WEST SUSSEX COUNTY COUNCIL CONSULTATION

TO:	Arun District Council FAO:Amber Willard
FROM:	WSCC - Highways Authority
DATE:	7 July 2022
LOCATION:	Land at junction of Hollyhock Way and Worthing Road Littlehampton BN17 6SH
SUBJECT:	LU/154/22/TEL Prior Notification under Schedule 2 Part 16 Class A for a proposed 5G telecoms installation: H3G Phase 8 high street pole c/w wrap-around cabinet: and 3 further additional equipment cabinets.
DATE OF SITE VISIT:	n/a
RECOMMENDATION:	Advice
S106 CONTRIBUTION TOTAL:	n/a

215 PROPOSED SITE PLAN

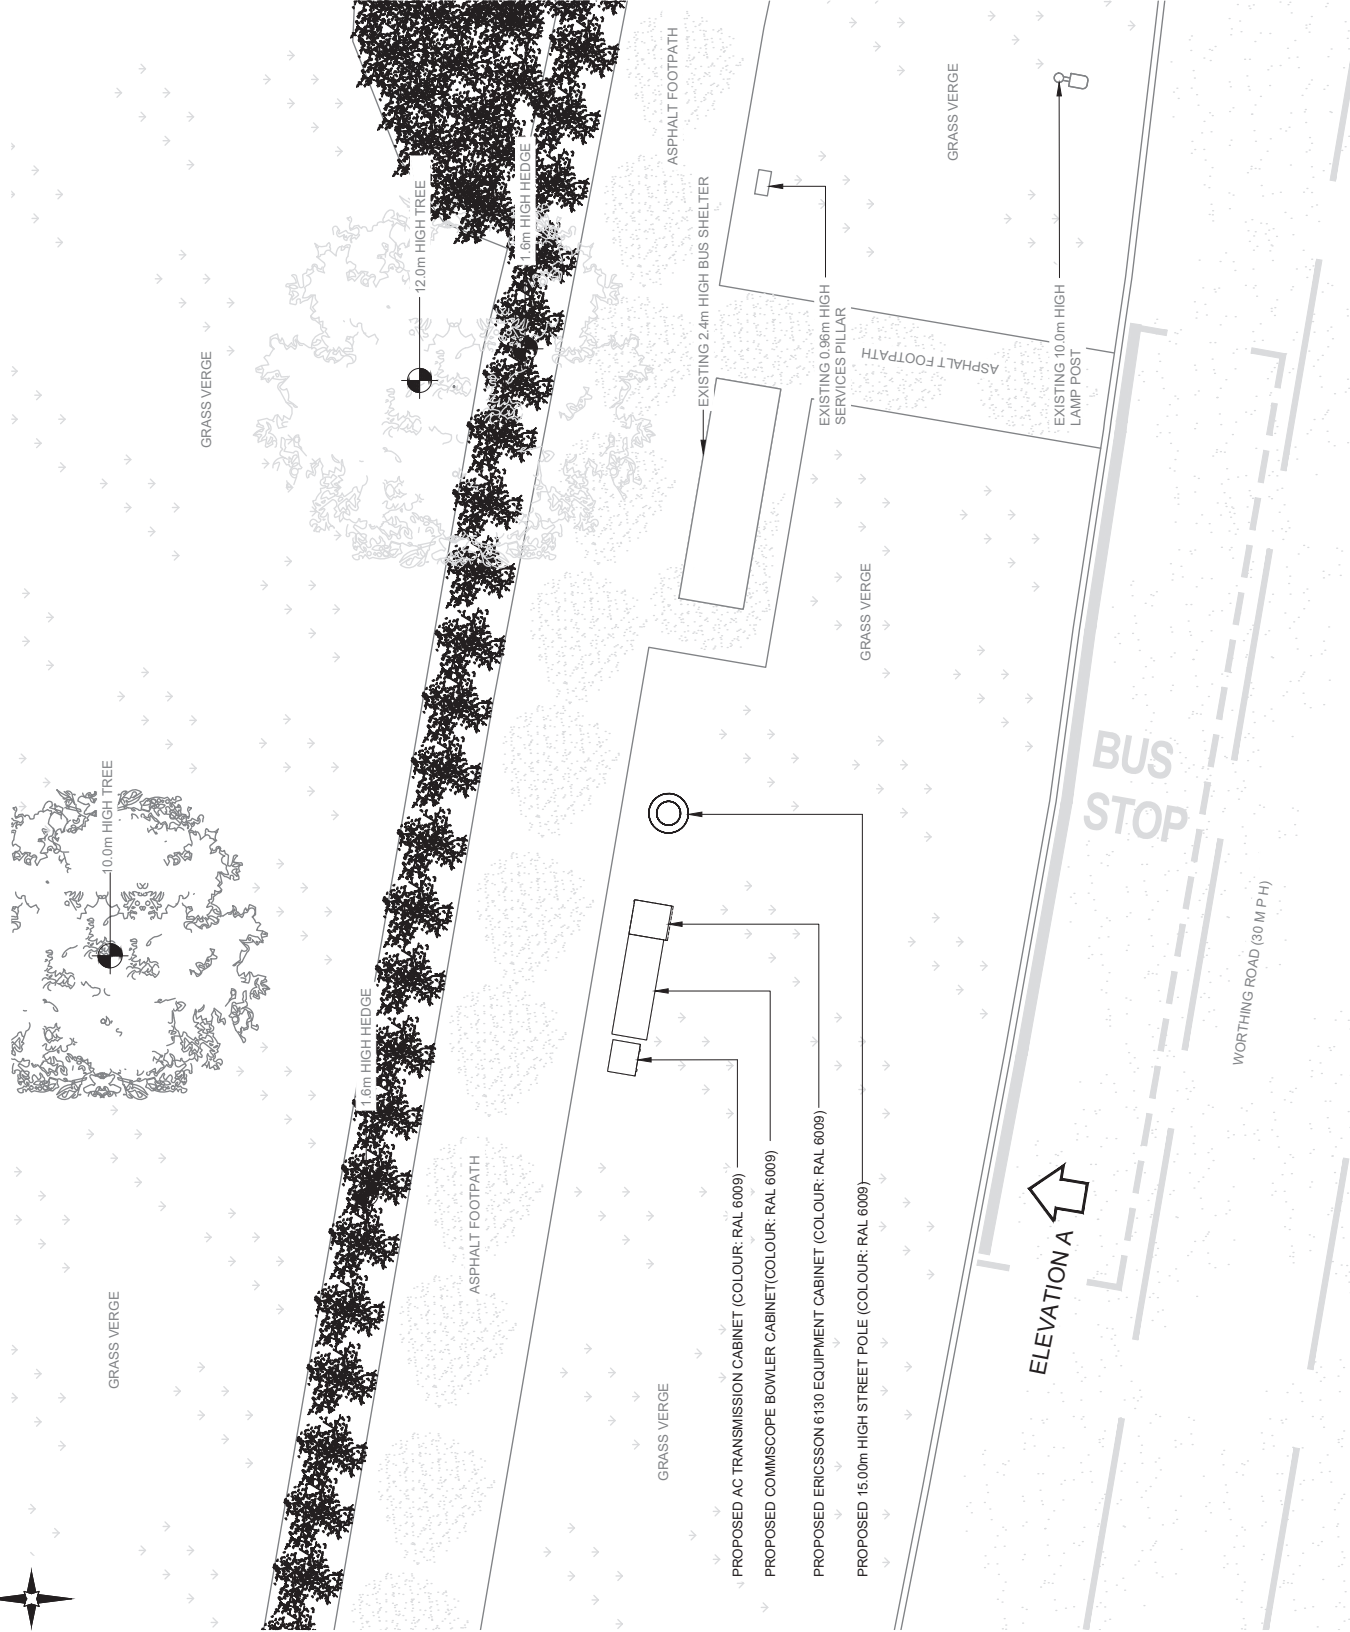
This Prior Approval is for installation of a a proposed 5G telecoms installation: H3G Phase 8 high street pole c/w wrap-around cabinet: and 3 further additional equipment cabinets. The cabinet equipment will be situated on Worthing Road (B-class road) close to the junction with Hollyhock Way (unclassified road) both subject to 30mph speed limit.

The proposed cabinets and pole are all located within highway boundary and not anticipated to obstruct visibility for vehicles travelling along the Worthing Road. At present there is bus shelter and other street furniture in close proximity.

The proposed equipment will be located on verge that has a footway. This proposal is not anticipated to result in an obstruction to any pedestrians who may be utilising or be seeking refuge within the existing footway.

The statutory undertaker will need to submit the necessary notification to the Highway Authority independently and any traffic management will need to be agreed with WSCC Highways prior to works taking place. Their contact details are included below.
